**Consultation Response from KC,  
Highways Development Management**

**2021/92904 Yangtze Chinese Restaurant, Park View, 149 Halifax Road, Liversedge, Dewsbury,  
WF15 6NU**

**Application for permission in principle for conversion and alteration of existing restaurant to  
form up to 9 self-contained apartments along with formation of associated hardstandings,  
parking areas and domestic gardens**

**Date Responded:18-10-  
2021**

DRAWING TITLE
EXISTING SITE PLAN
CLIENT

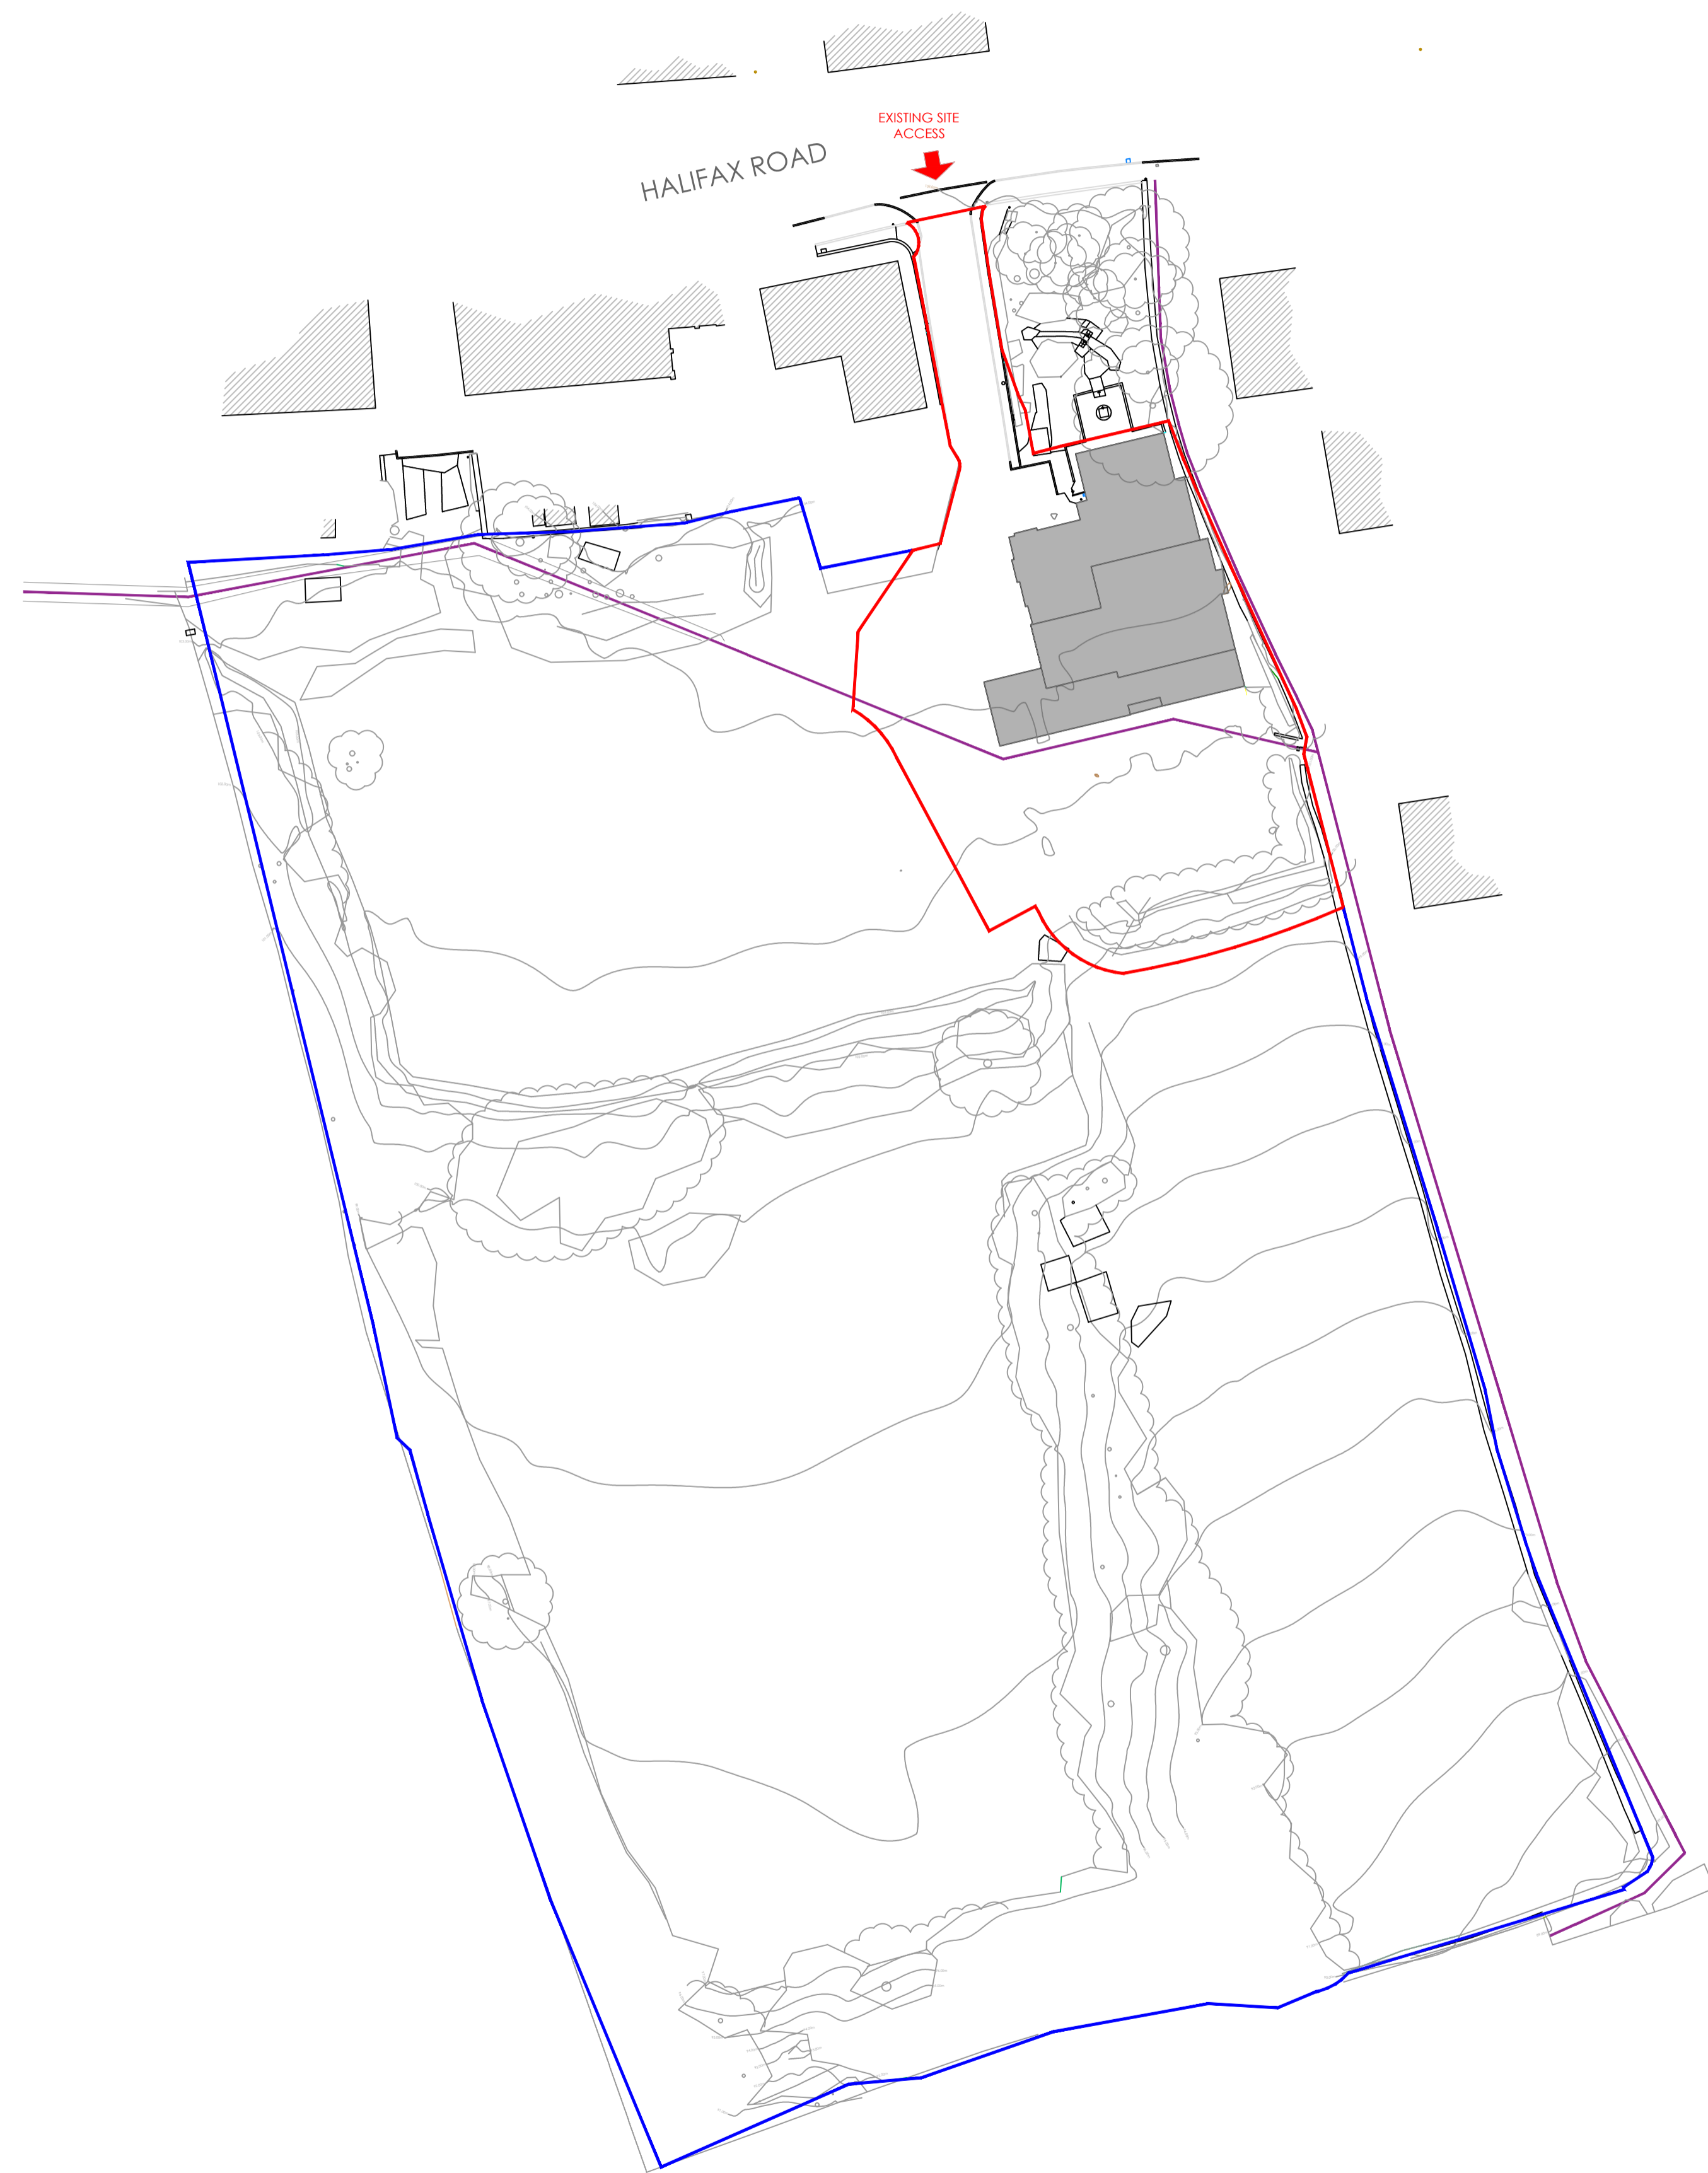
The plan shows an access road with a narrow footway to the western side only.

No demissions plans are provided of the proposed access road or turning head and no swept paths are provided to demonstate that a refuse vehicle can enter,exit and turn within the site. No details of the proposed sight lines from the access onto Halifax Road are shown on the plans.

1,Appropriate sight lines should be demononstrated from the access onto Halifax Road. Sight lines should be based on the 85 percentile speed of vehicles along Halaifax Road.

2,Acceptable arrangements for refuse and emergency vehicle access should be shown to be provided including swept paths for an 11.85m refuse vehicle.

3,Improved pedestrain access should be provided from Halifax Road to the proposed access to the 9 flats.
